OUR REFERENCE 7597

**Civil Engineering Response Note Surface Water Drainage & Flooding Concerns Proposed  
Extension to Drumcliff Burial Ground ACP Ref: 323742-25**

To An Coimisiún Pleanála

CLIENT: Clare County Council
TITLE: Watermain & Storm Water Sewer Layout

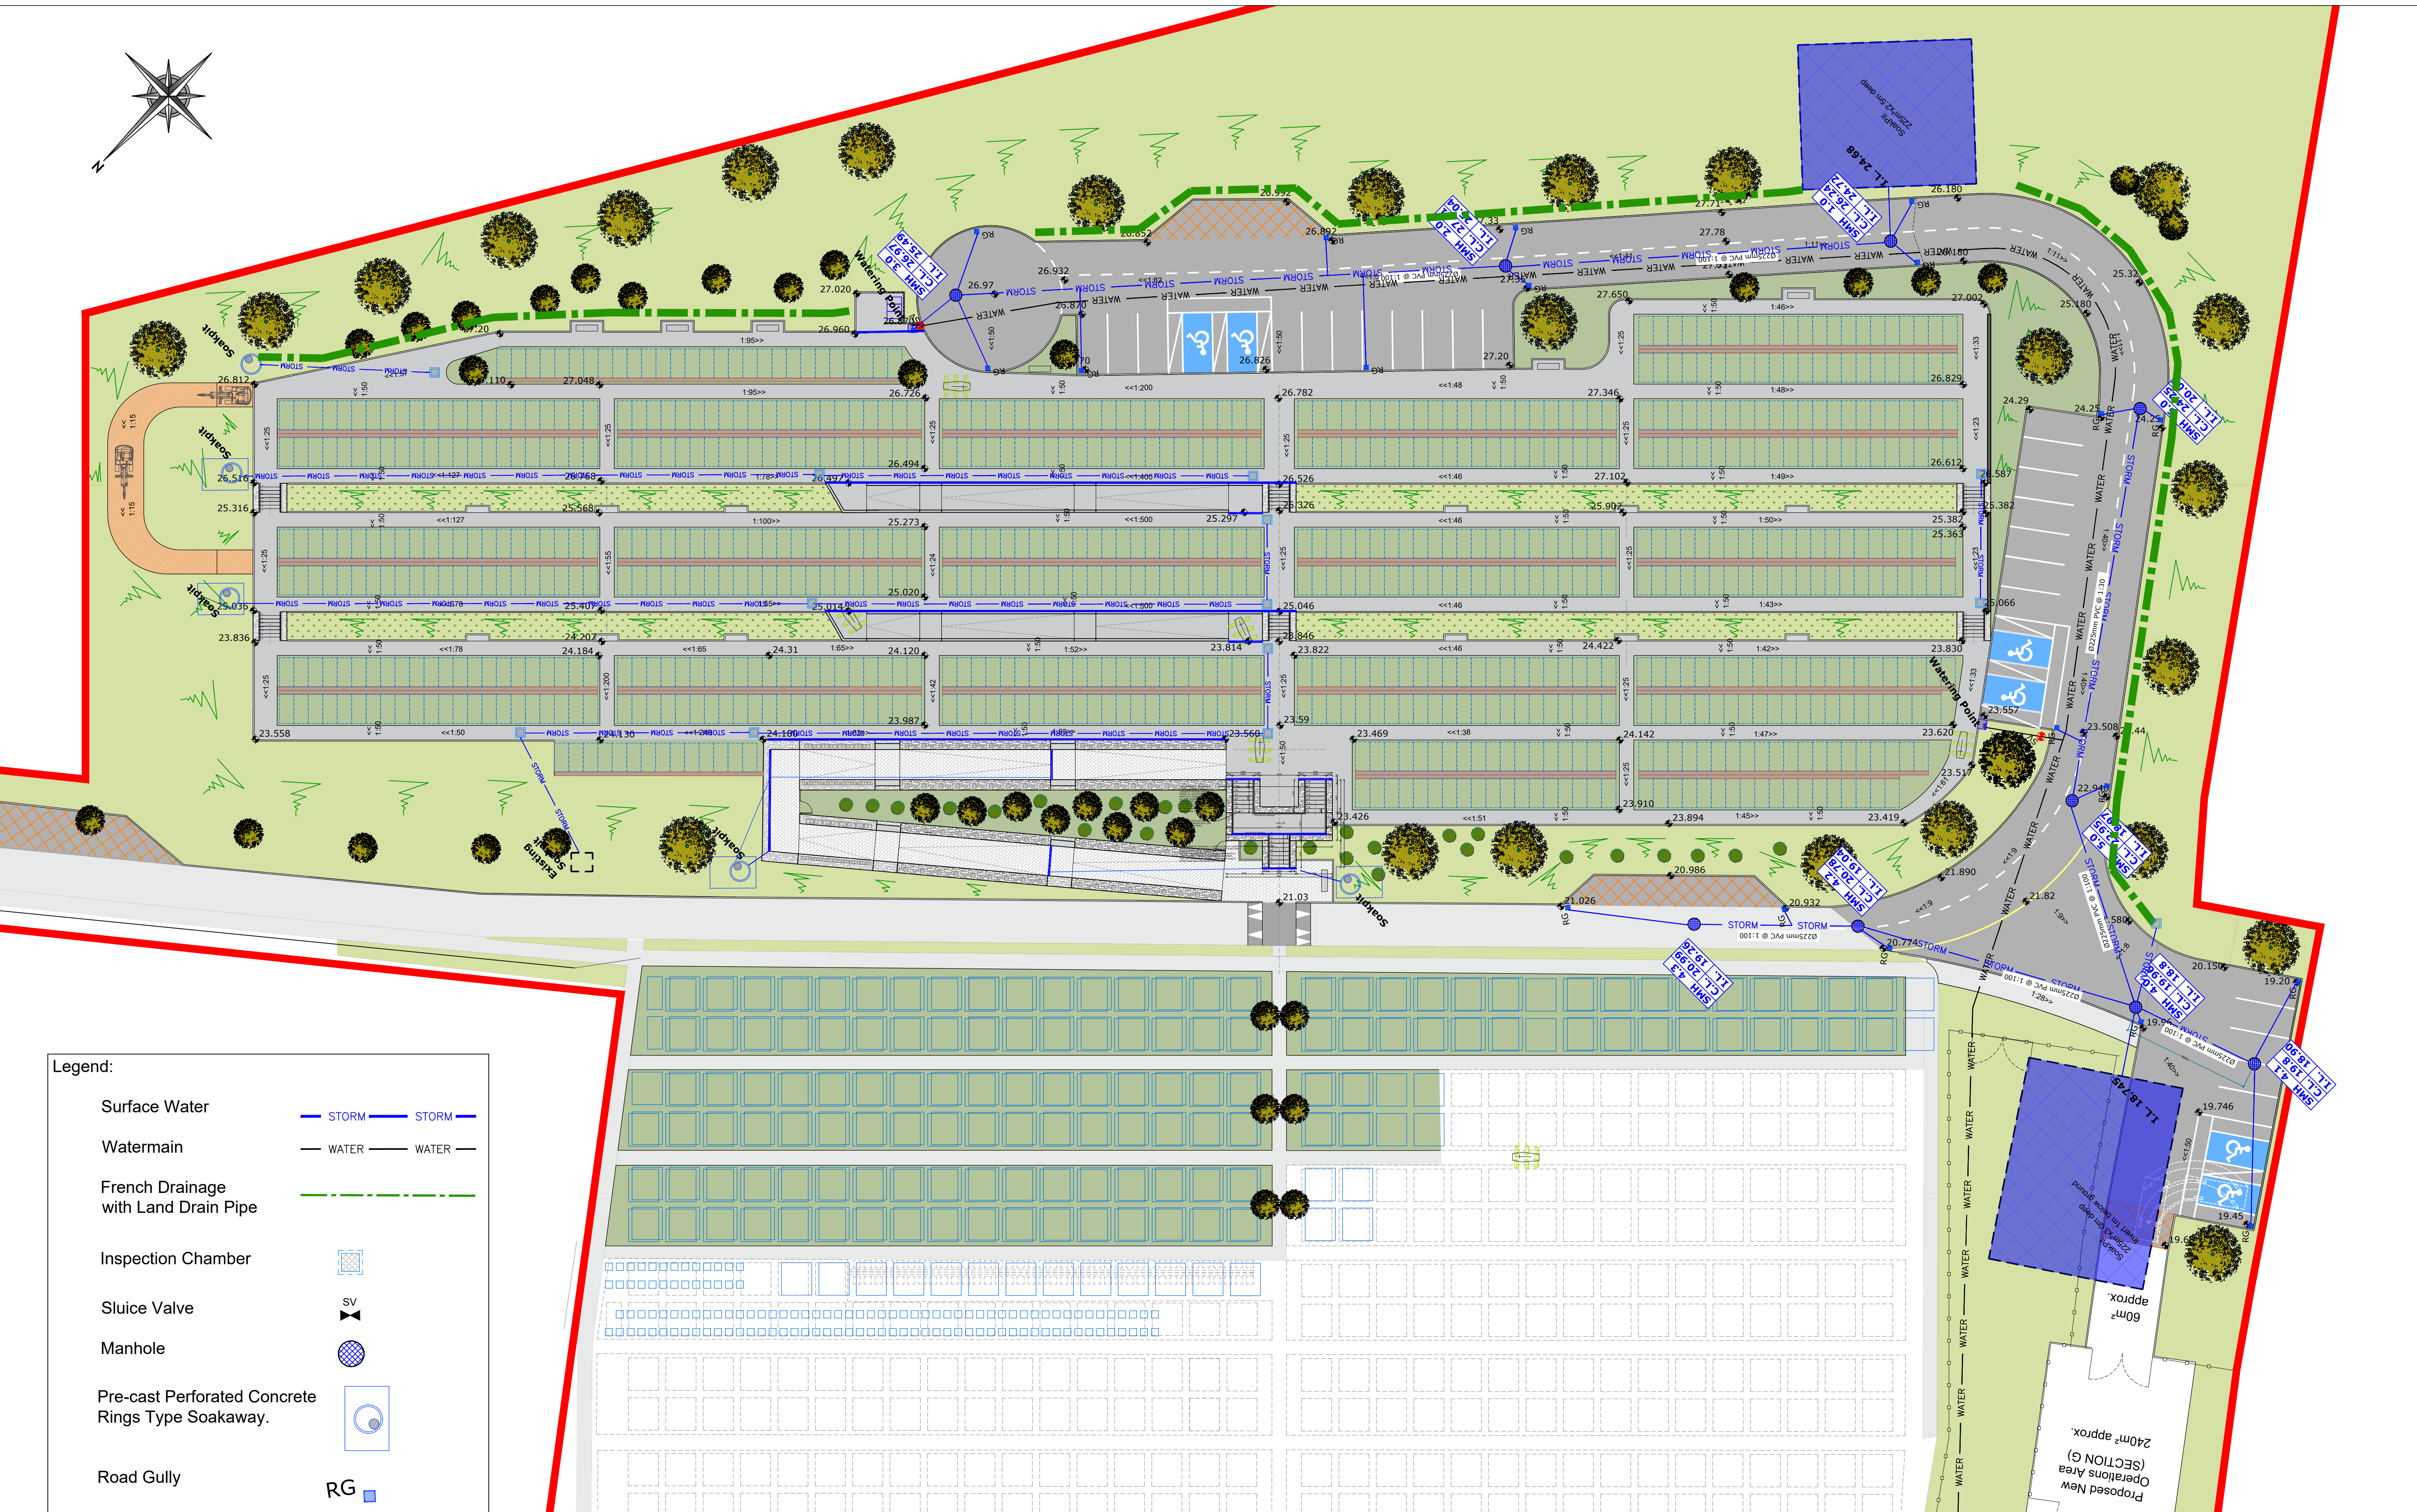
In response to the flooding and soakaway concerns raised by Mr Robert Behan, Mr Pat Tierney and Mr Dermot Queally:

The detailed drainage design for the proposed extension (Drawing No. 7421-200 Rev B, dated September 2025) has been prepared in full accordance with SuDS principles and Objective CDP 2.11(c) of the Clare County Development Plan 2023-2029. All surface water generated on the proposed extension will be captured and fully infiltrated on-site via soakaways and direct infiltration into green areas. There will be no discharge from the site to the public road or any downstream lands.

- The site is underlain by 8.5–13.5 m of low-permeability boulder clay, confirmed by trial pits carried out on-site in 2022 and 2025, together with geophysical survey.
- Surface water falling on green (grave) areas will infiltrate directly into those areas.
- Footpaths are sloped toward adjacent green areas or collected via ACO drains and directed to dedicated soakaways.
- Roadway runoff is served by French drains with land-drain pipe leading to a dedicated soakaway at the lowest point of the drainage run.
- Gullies at the existing/proposed roadway junction and the main pedestrian access ramp/stairs are served by dedicated soakaways.

The two soakaways were sized using the results of five BRE Digest 365-compliant soakaway tests carried out in the trial pits on-site. The system ensures zero increase in surface-water runoff from the development.
